From: Simmons, Maxine
Sent: 25 January 2023 11:34
To: _planningadvice
Subject: FW: H04-1112-22 Off Town Dam Lane

Drawing
SITE PLAN - PROPOSED
LOCATION PLAN

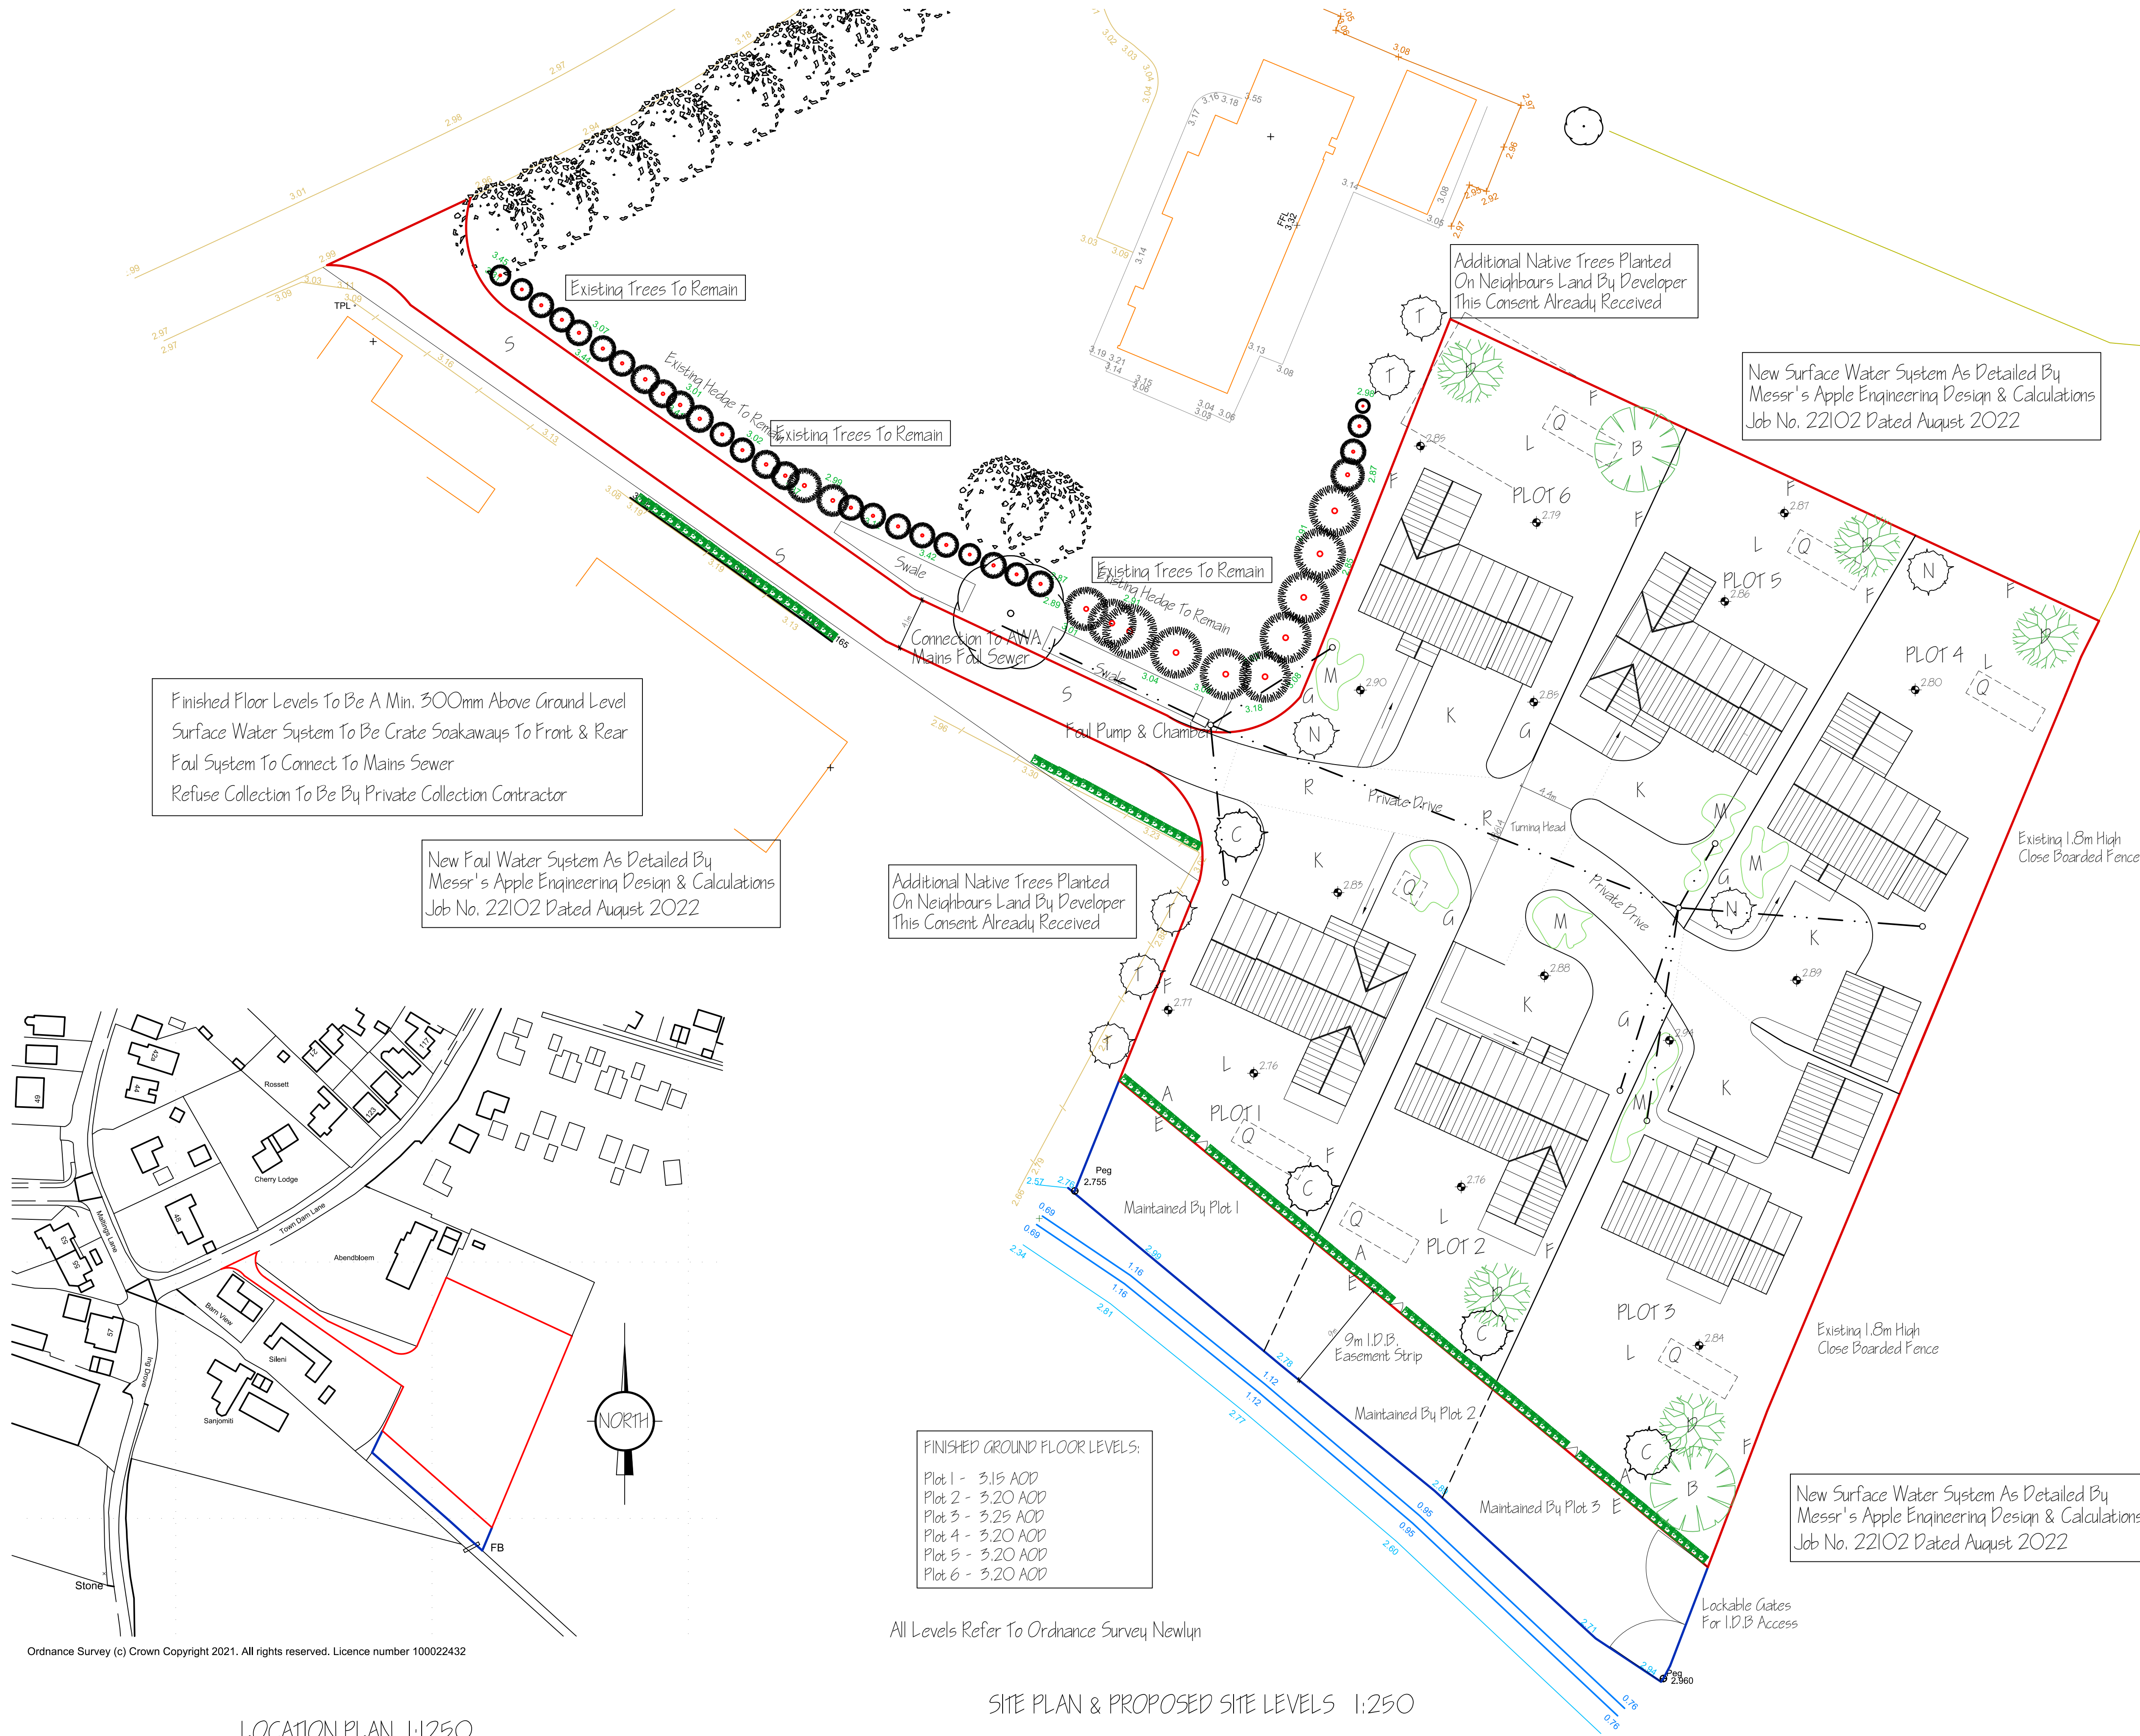
Thanks for your email, and I've been thinking about this, but unfortunately the planning records need to be reconciled. Clearly there is a difference with the approved site location plan and the current site location plan

under consideration. The approved plan is shorter. Building Control records can't be used to rectify a planning discrepancy.

I can see that the approved application does have a 3.5m projecting gable for plot 5 as a *floor plan*, but the site location plan is different.

Amendment to plot 5 to show 3.5m rear gable on site location plan.

It appears in the approved scheme the floor plans didn't accord with the site location plan.

We agree to Amendment to plot 5 to show 3.5m rear gable on site location plan being added to the development description.
